Ref: D2015/126797

Light Weight Aggregate Facility, Wallgrove Road, Horsley Park – SSD 6820

I refer to your letter of 2 November 2015 inviting comment on the above development application at 780 Wallgrove Road, Horsley Park.

Figure 5: Aerial Imagery of Sensitive Receptors with respect to Project Site

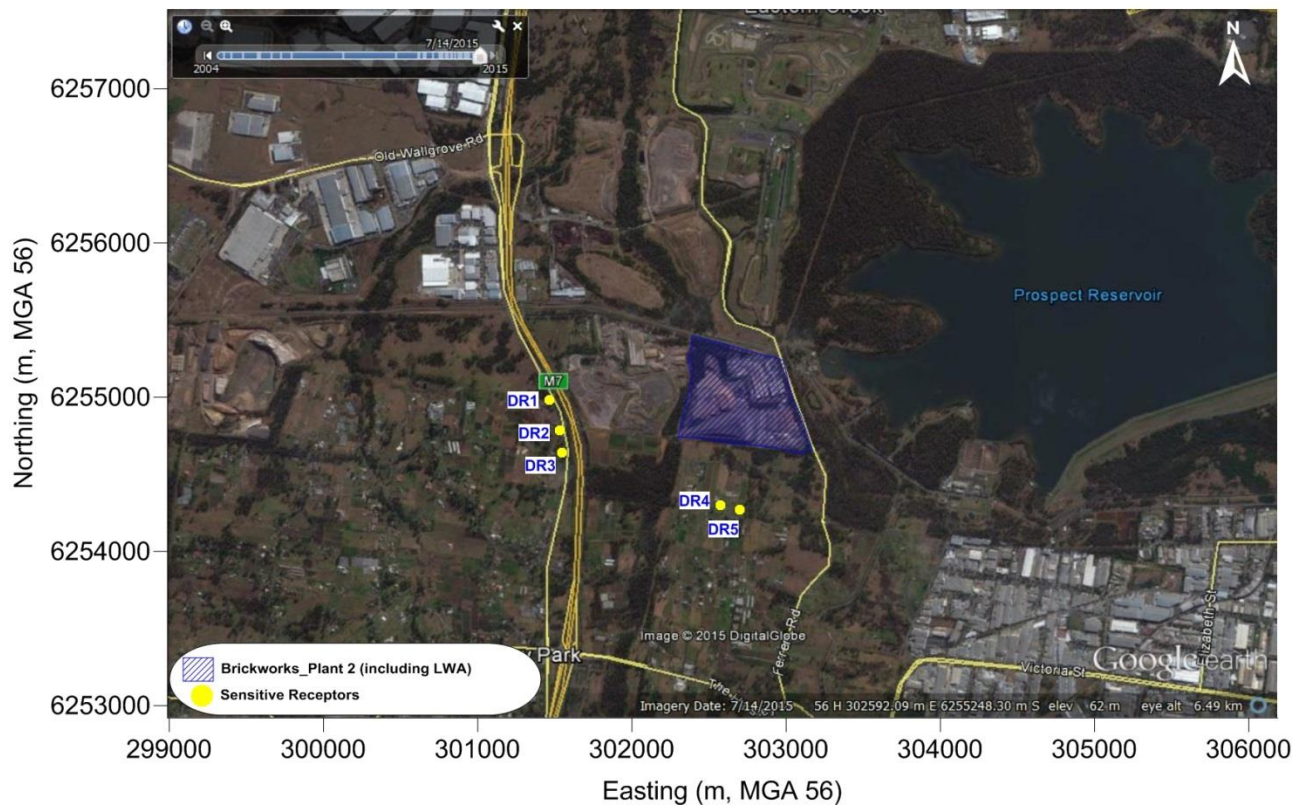
WaterNSW's Prospect Reservoir and Upper Canal are located to the east of the site. The air quality impact assessment does not include the site as a sensitive receptor. We request assessment of the potential water quality impacts to the open Upper Canal water supply and Prospect Reservoir from kiln emissions.
